Project Address: Proposed Development for 94 Dwelling Units at lands 150m North of the N55, Lissywollen, TD, Athlone, Co Westmeath.

Project Reference: 127

Response to submissions received from Development Applications Unit

Re: Part 10 Planning Application – Proposed Development of 94 Dwelling Units at Lands 150m North of the N55, Lissywollen TD., Athlone, Co. Westmeath

Annotated by	EG & CD	Sheet	2A0
Date	30-06-2025	Drawing No.	TPR-CM-01
Scale	1:500	Revision No.	1

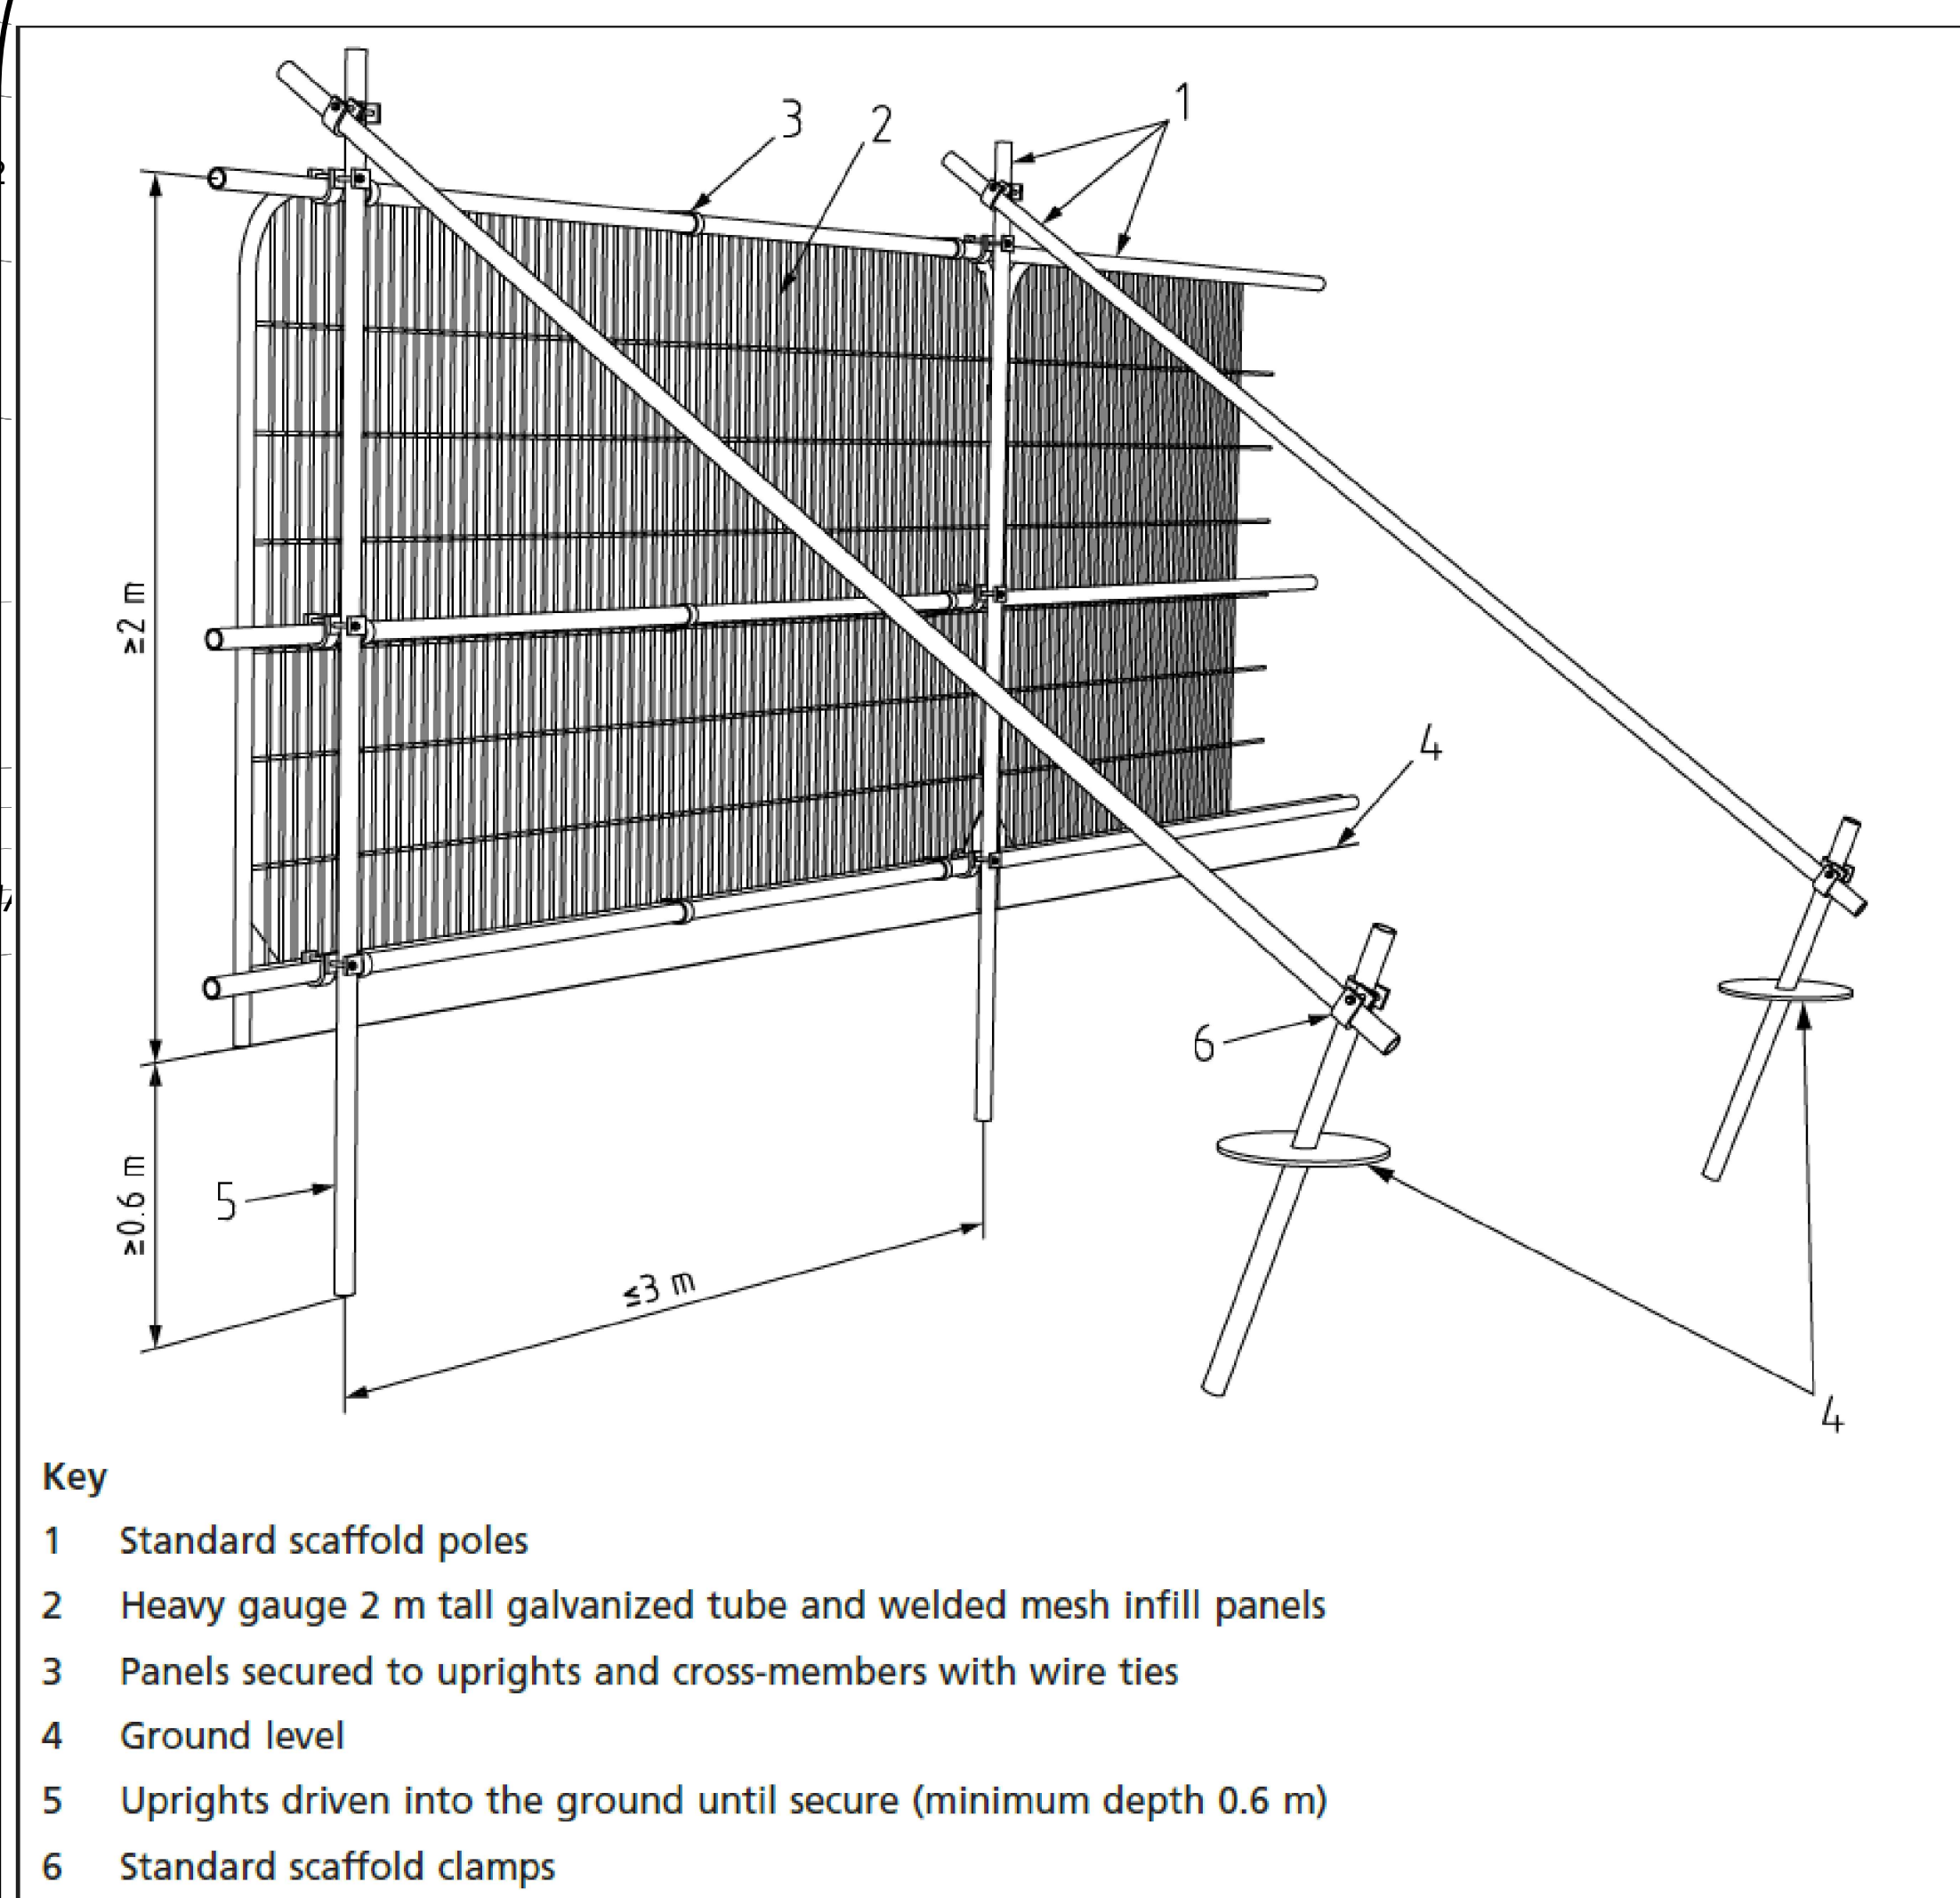
The EclA asserts that while it is intended that those trees and hedgerows of highest ecological value on site are to be retained, some vegetation removal may be necessary and would be replaced elsewhere on site by the planting of native species. However, it is recommended that all potential roost features within the treelines and hedgerows should be retained as a first preference to protect unidentified bats roosts on site and vegetation of higher ecological value that cannot be easily replaced in the short-medium term by replanting alone."

WCC recognised the ecological importance of the site's trees and hedgerows from the outset, hence the proposed layout wholly maintains the existing hedgerows and trees. The proposal identifies the removal of a section of hedgerow in preparation for the housing developments new site entrance.

Furthermore the tree protection plan included in the Arborist report proposes the removal of trees that are at end of life or are a danger of collapse, for which a plan for limb removal or complete removal has been identified, these works will be carried out as per the EclA recommendations to ensure these works minimise any affects to roosting Bats.

The proposed break through of the site entrance is done with much consideration in respect of the loss of habitat. The break through of the site entrance was also considered in relation to the disruption of the wildlife corridor. WCC confirms that the remaining section of wildlife corridors will remain connected to larger zones of corridors and natural habitat. Any new planting of native species of plants and trees will be done so as a compensation for the loss of habitat at the site entrance.
